Reference No: 2020/62/92004/W

Site Address: 3, Reinwood Avenue, Quarmby, Huddersfield, HD3 4DP

Description: Erection of two storey side and single storey rear extensions

DECISION – CONDITIONAL FULL PERMISSION

REAR CONTEXT ELEVATION AS EXISTING_
Scale 1_100

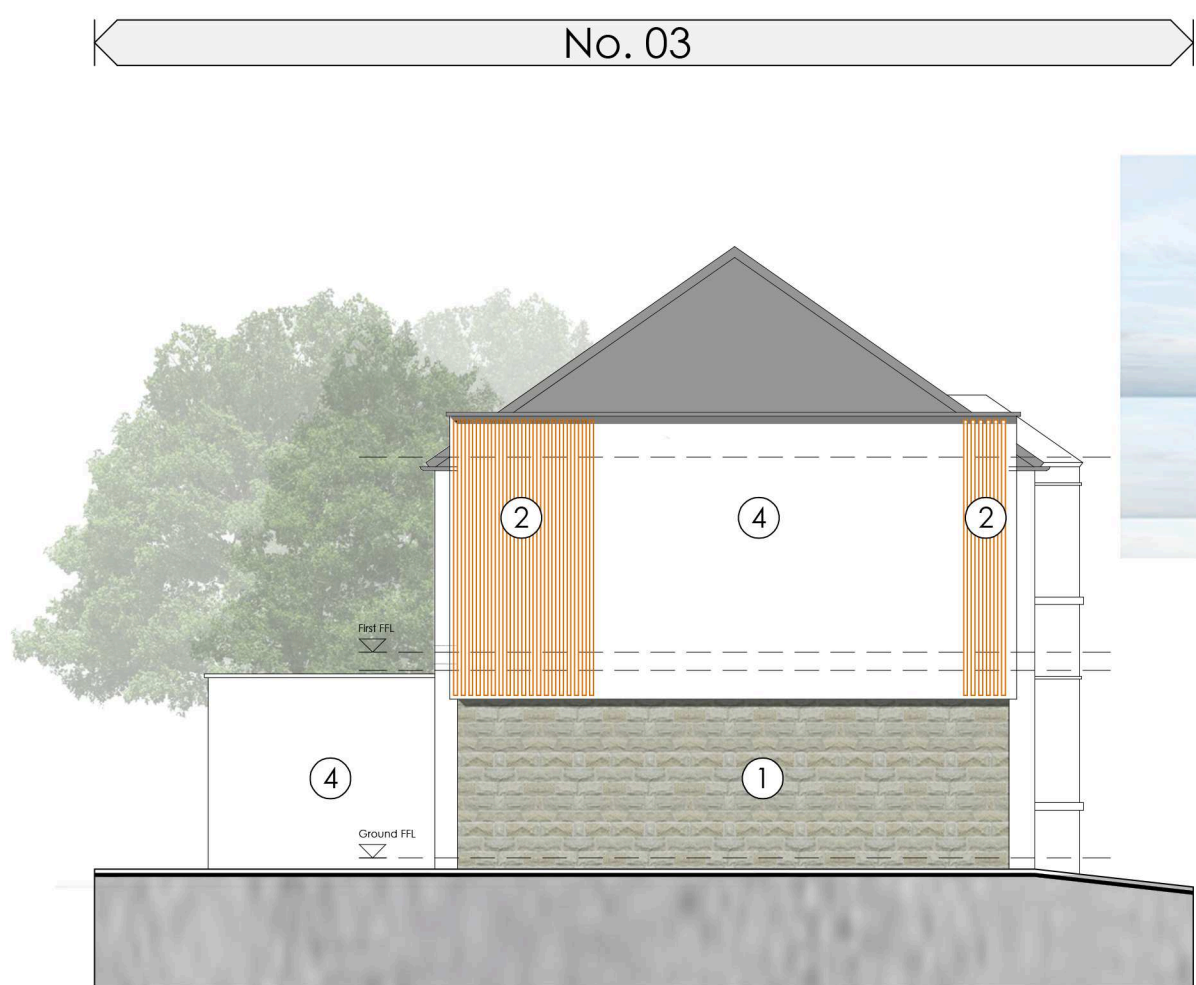
Concerns were raised with the initial submitted proposal due to the proposed flat roofed two storey extension and the proposed construction materials. In response, the plans have been amended with the alterations summarised as follows:

- Traditional roof form added
- Removed timber elevations at first floor and replaced with white render
- Window details amended to be more in keeping with the existing

- Retained stone at ground floor
- Extended the rear elevation across the rear of the two storey extension

The design of the proposal has been amended from a two storey flat roof timber clad structure to a more traditional structure which would be rendered to the first floor with a white coloured finish. Whilst this would introduce a new finishing material to the property, the neighbouring property has a rendered first floor and there are properties within the street scene that are finished with a white coloured render and therefore the use of such a material is considered acceptable. The use of timber cladding has been significantly reduced. Furthermore the roof has been redesigned to be in keeping with the hipped roof design of the existing dwelling.

The window openings have also been amended and are more in keeping with the host dwelling and therefore also considered to be acceptable.
